| Our Ref: | NE/22/00422/FUL |
| Date: | 7 April 2022 |

Proposal: Single storey front extension (re-submission of NE/21/00666/FUL) at 1 The Drift Collyweston Stamford PE9 3PH.

1 East Elevation  
TD-08 70 01 1:50

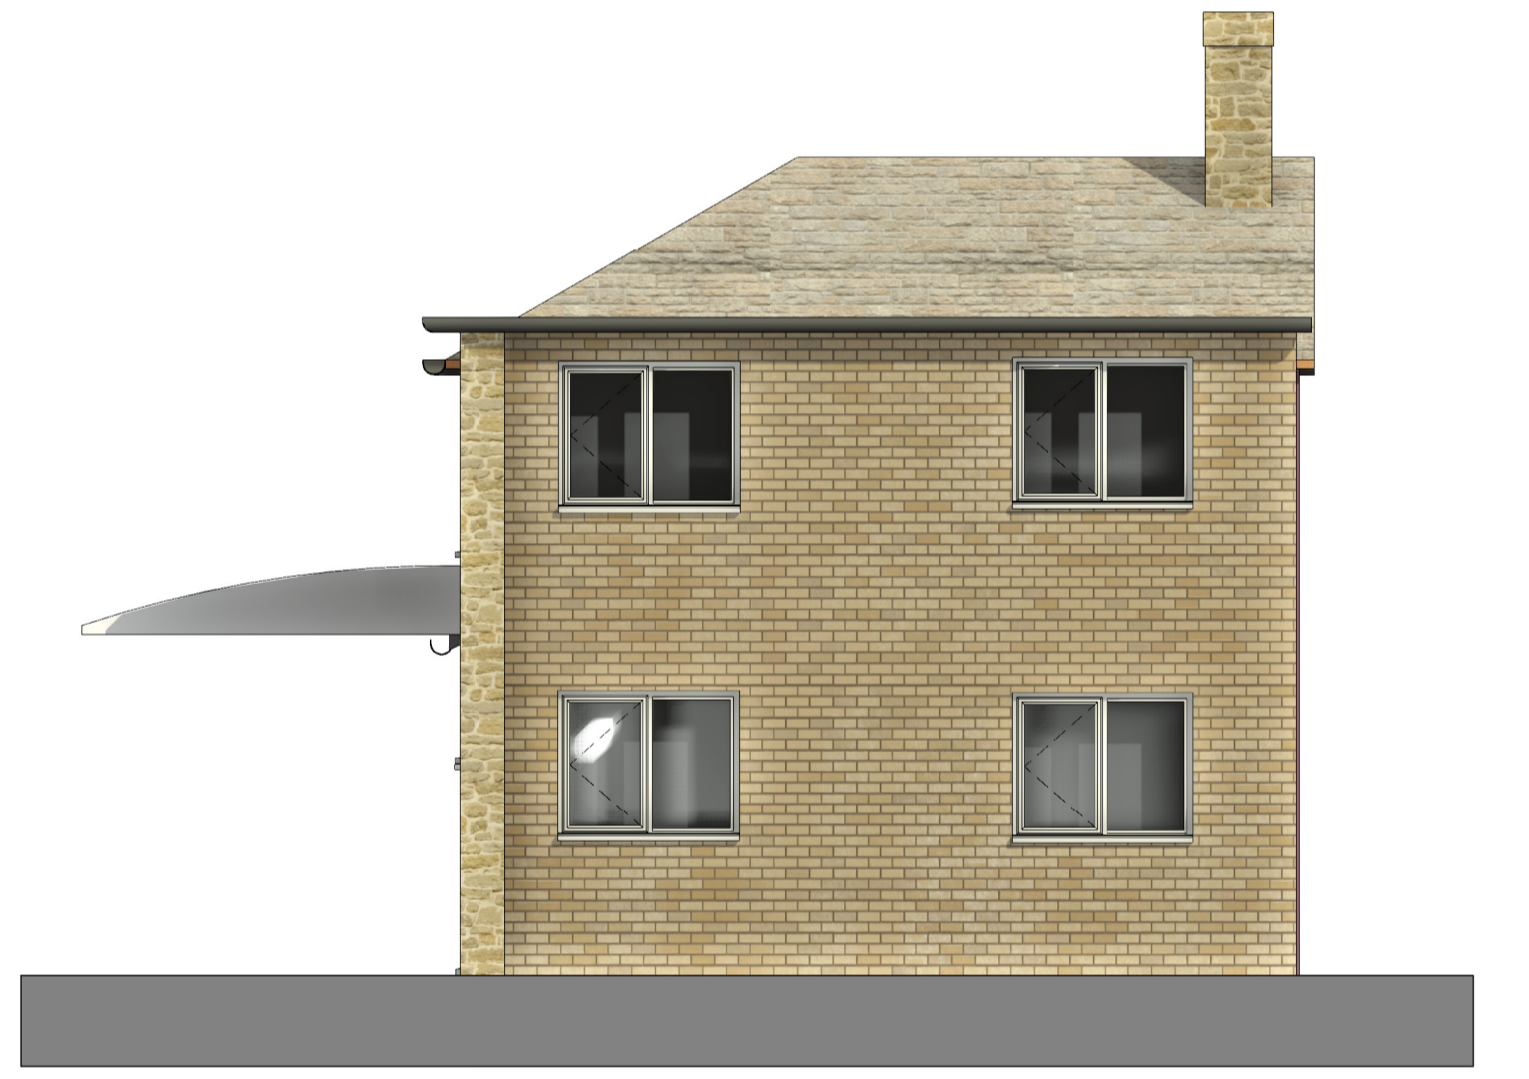
1. Thank you for the drawings submitted with your application, even though the scale used has been given all the relevant dimensions have not been provided. As per our published Local Requirements, "All plans and drawings must be drawn to an appropriate metric scale (1:50 or 1:100) and have all relevant dimensions of the key elements of the proposal clearly written. This includes the height, length, width and (if relevant) the distance from the site boundary of any proposed works. We require this so that the proposed dimensions are clear when plans are viewed online." This is required as we now run a completely paperless planning office.

Please provide amended drawings including all relevant dimensions of the proposal:

- Dimensions for the existing and proposed floor plan
- Dimensions for the existing and proposed elevations annotated with all height dimensions

Therefore, please give your written authorisation for this statement to be removed from the drawings or to be altered to read "For planning purposes only". On amended drawings, submitted please remove or alter this statement.
